**Re: PA22-040 – 87th & 40th PRD – Technical Review 3
4218 / 4112 / 4018 / 3922 / NNA 87th Ave NE
CORE Project No. 21036**

The purpose of this letter is to provide a response to the review comments for PA22-040 – 87th & 40th PRD – Technical Review 3 - 4218 / 4112 / 4018 / 3922 / NNA 87th Ave NE dated January 2, 2024. We have addressed each comment and revised the plan/documentation accordingly. This letter contains the review comments immediately followed by our response to each in bold lettering.

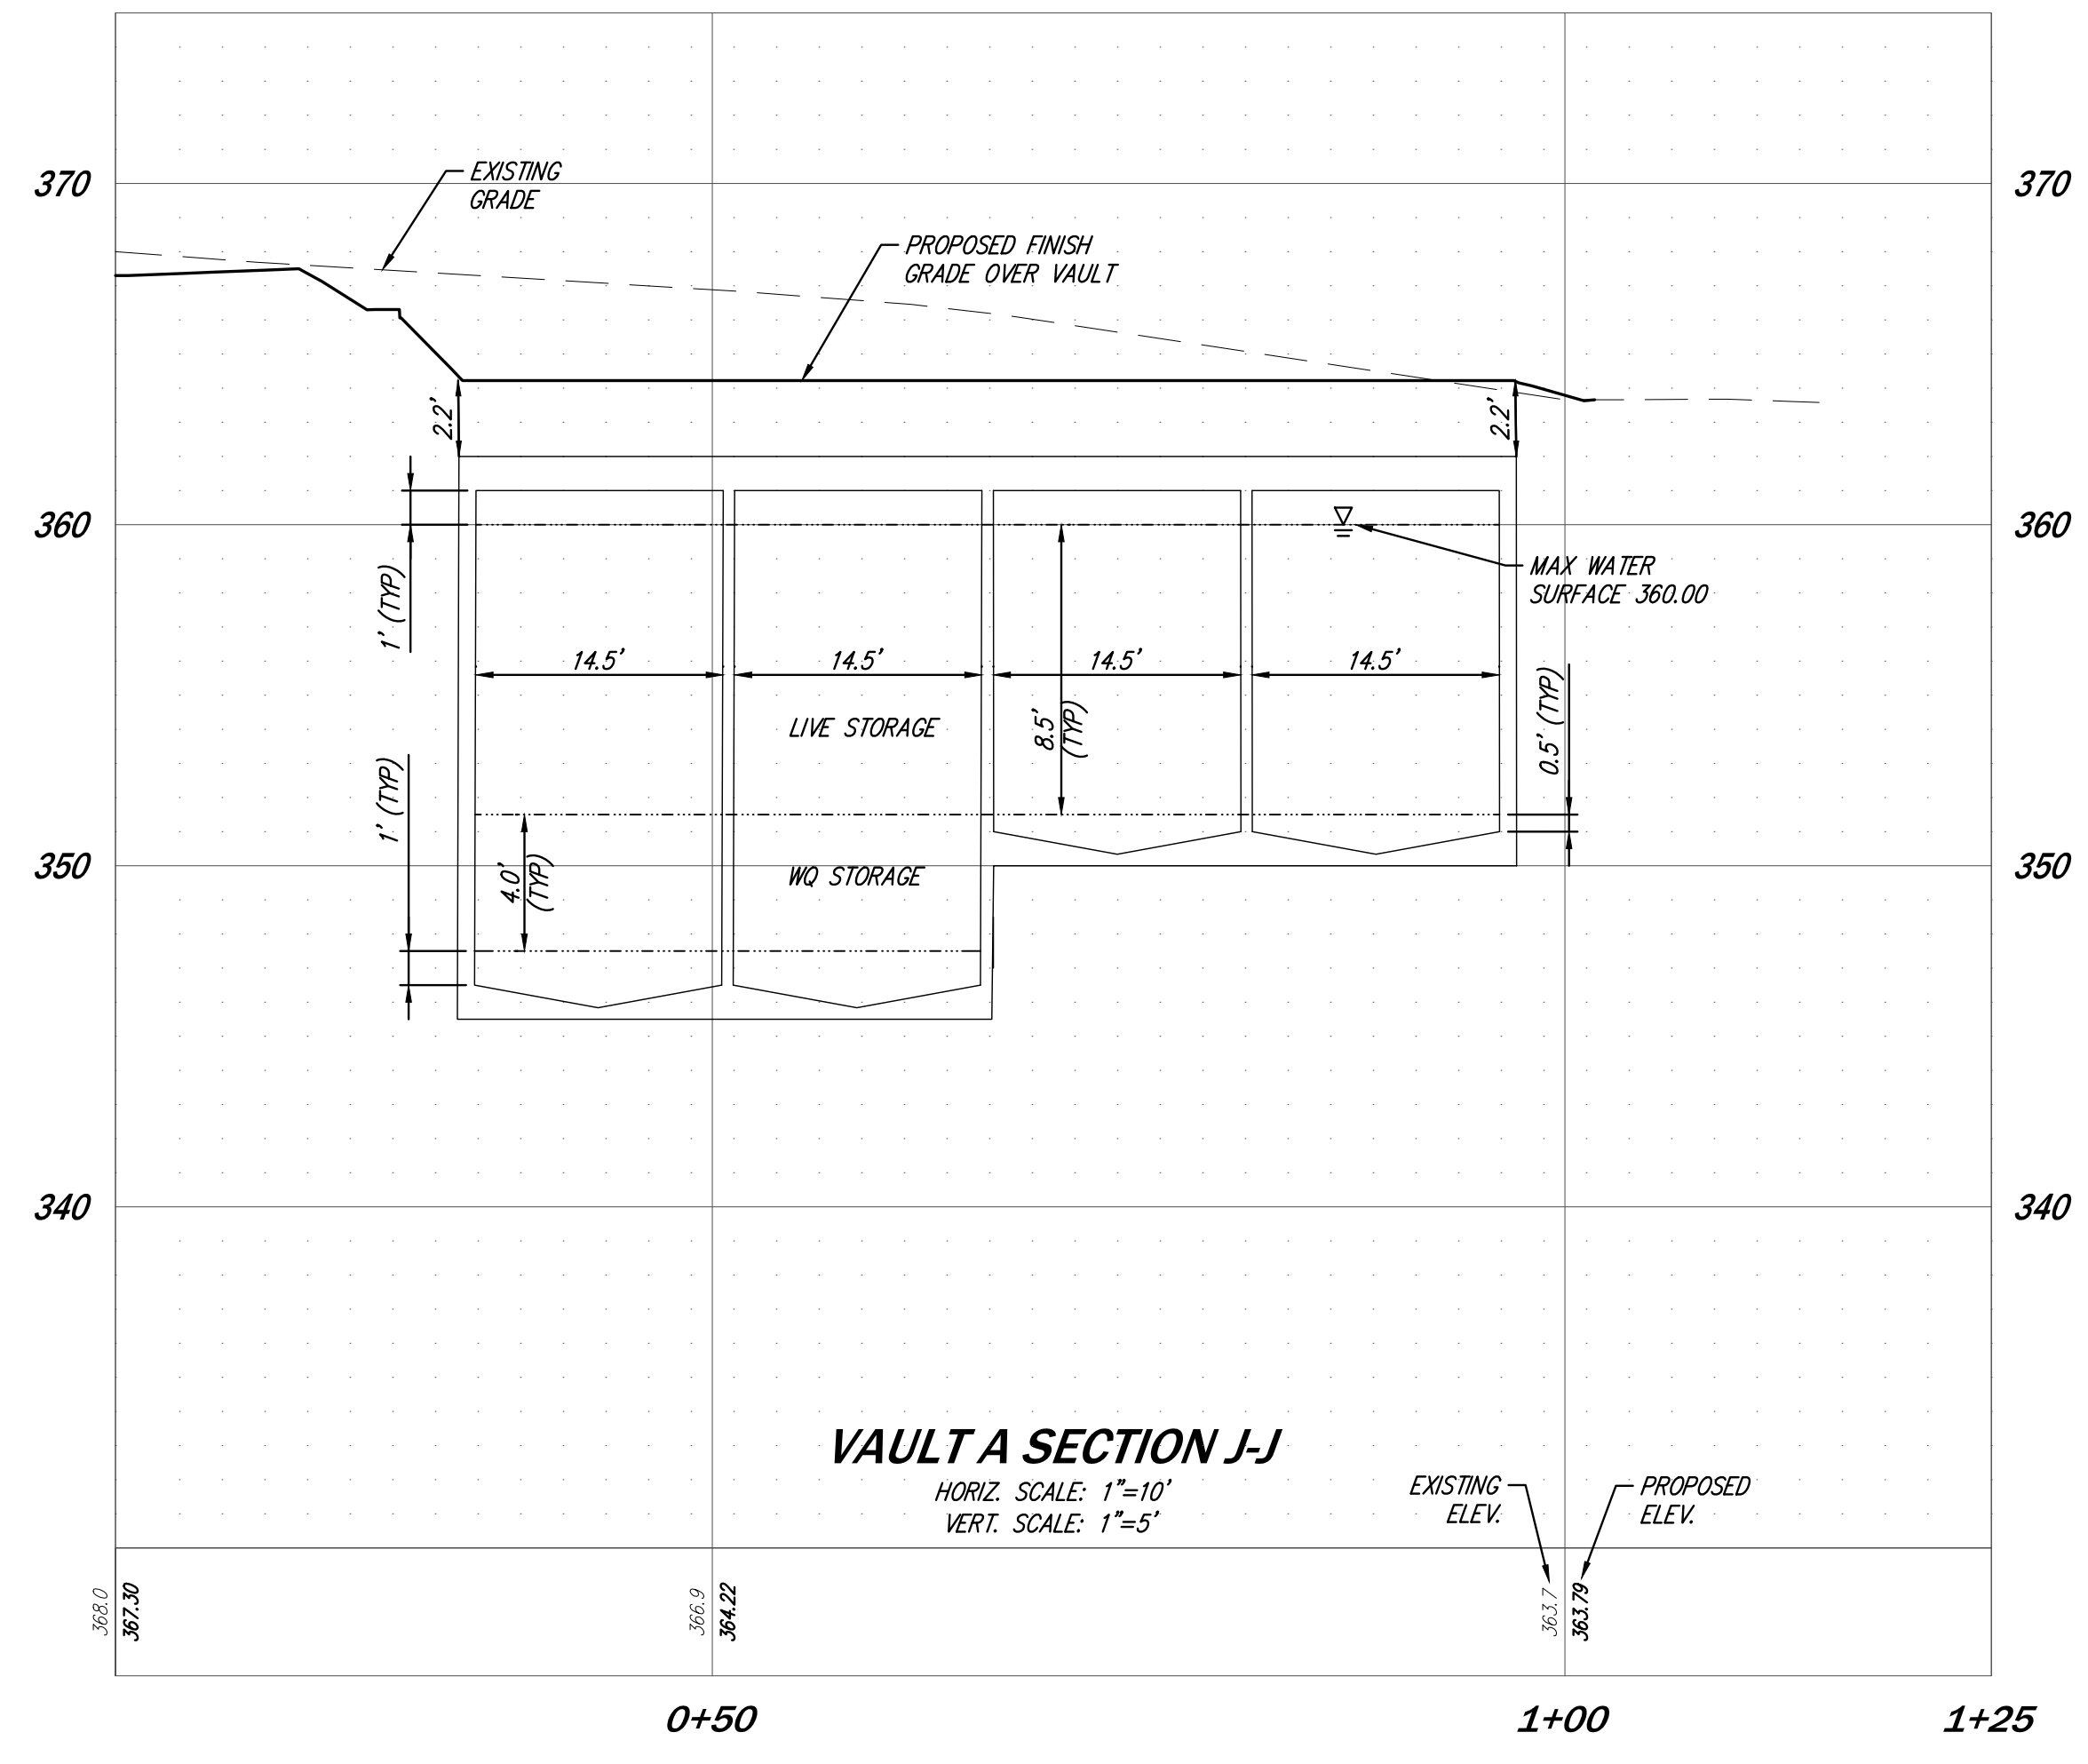
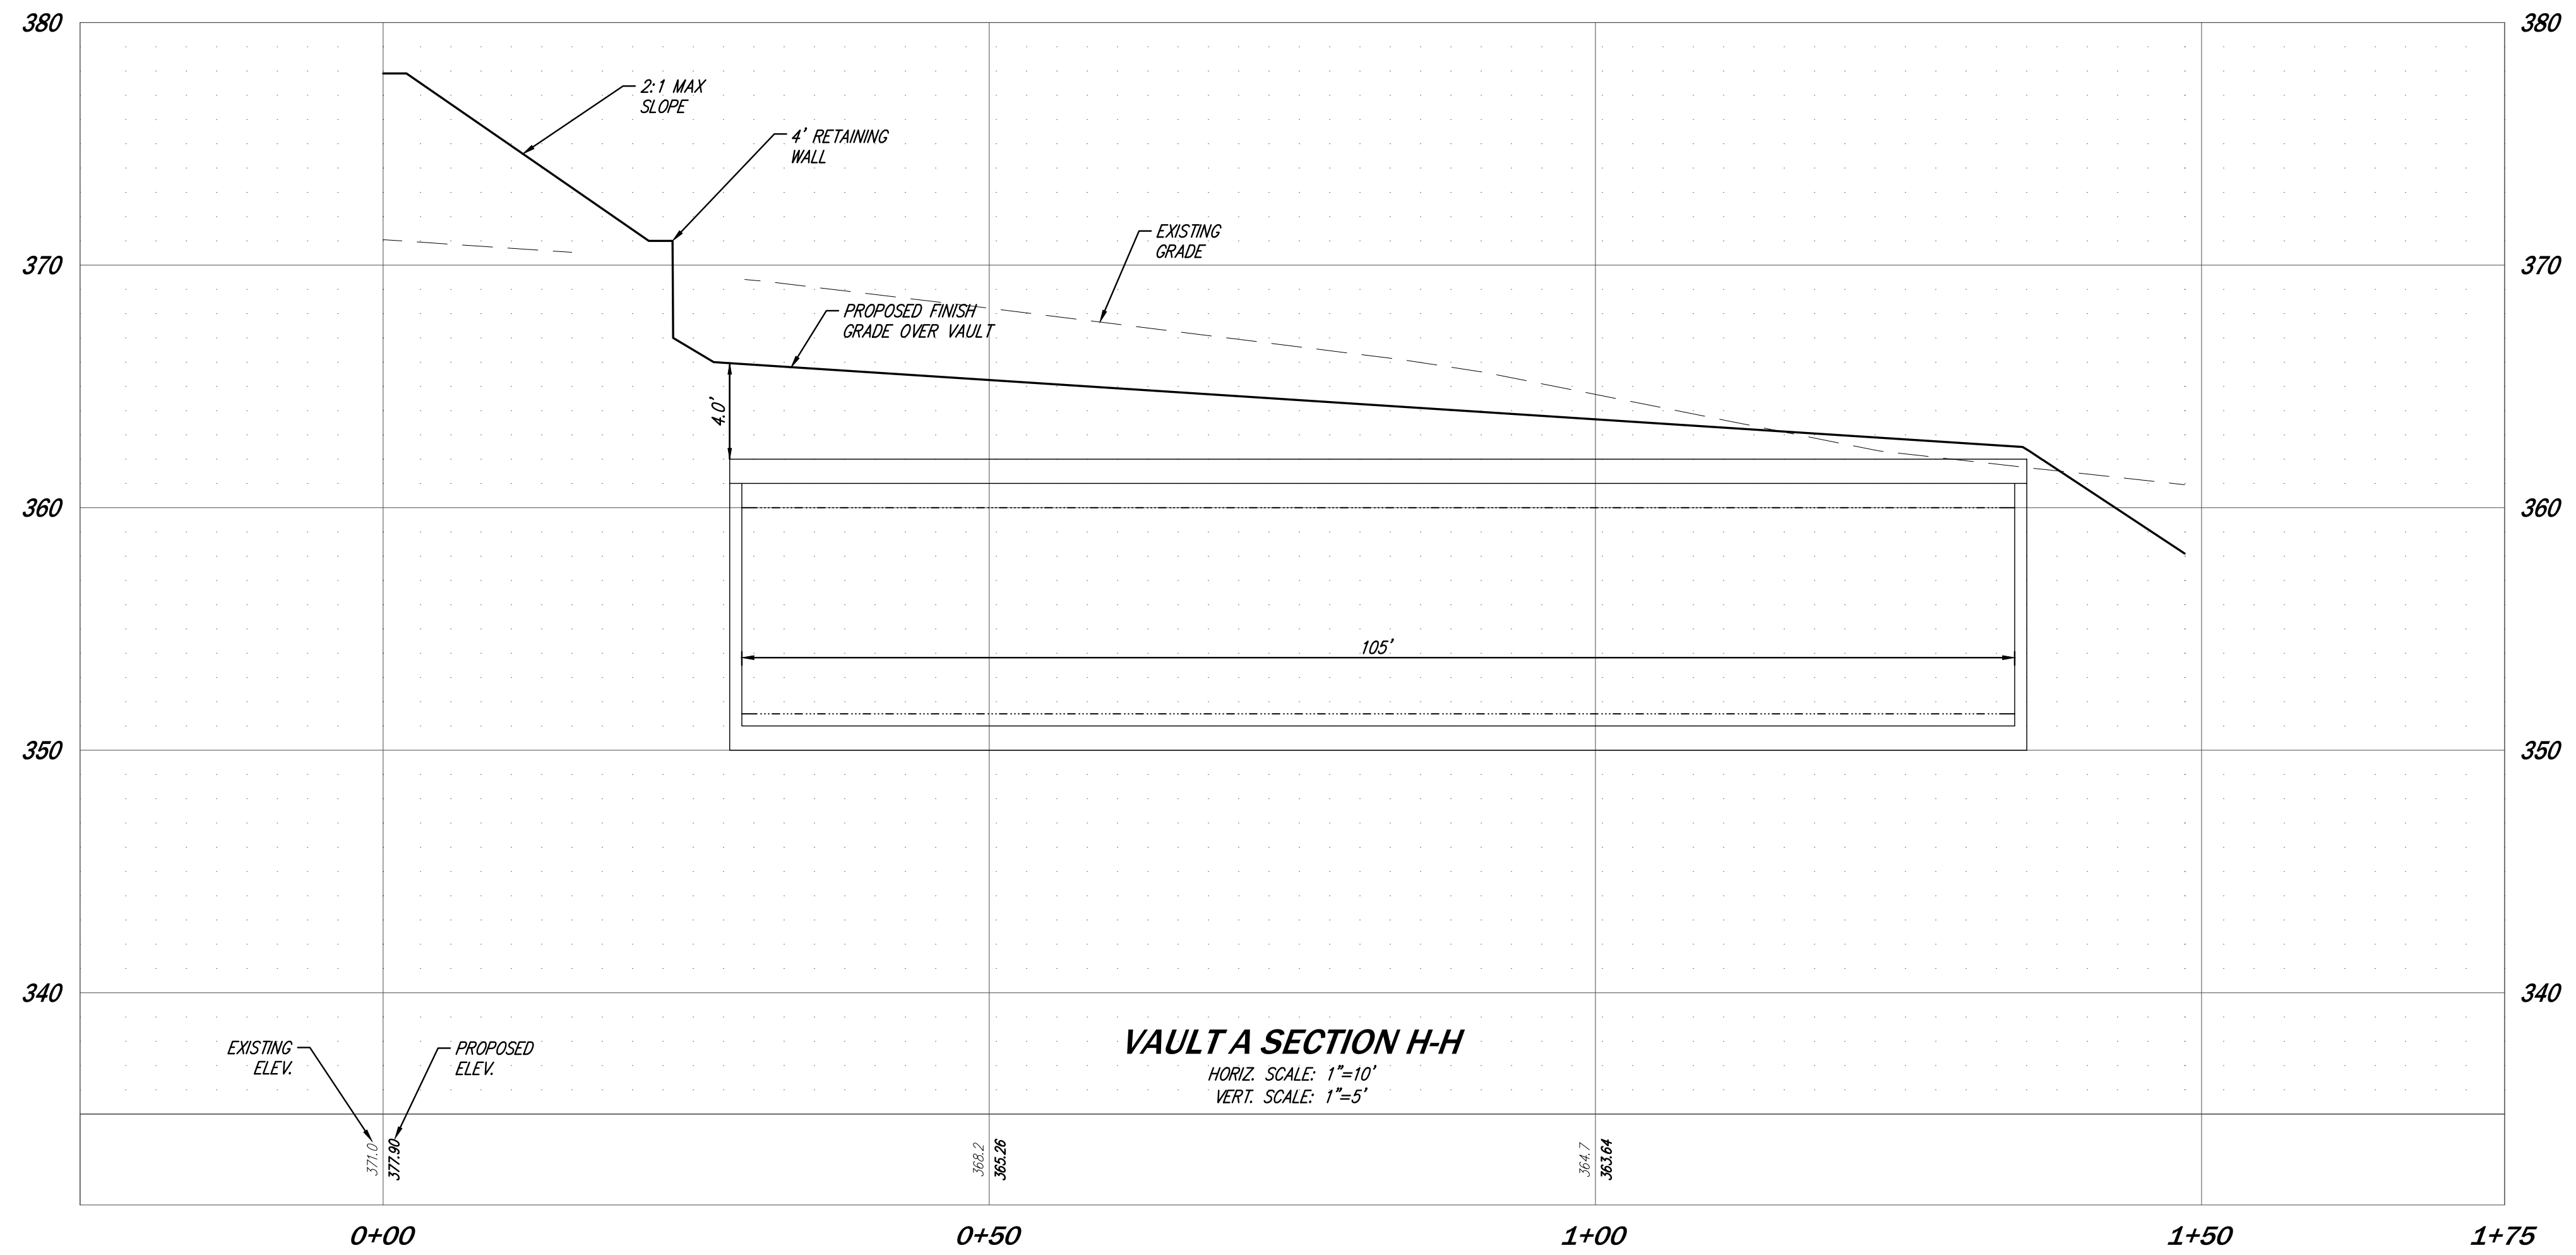
- b. 85th Ave NE will need at least 20’ of pavement. Please show revised plans accommodating 20’ of pavement.

Response: The proposed design has been revised per this comment. The Preliminary Engineering plans now show 85th Ave NE providing 20’ of pavement.
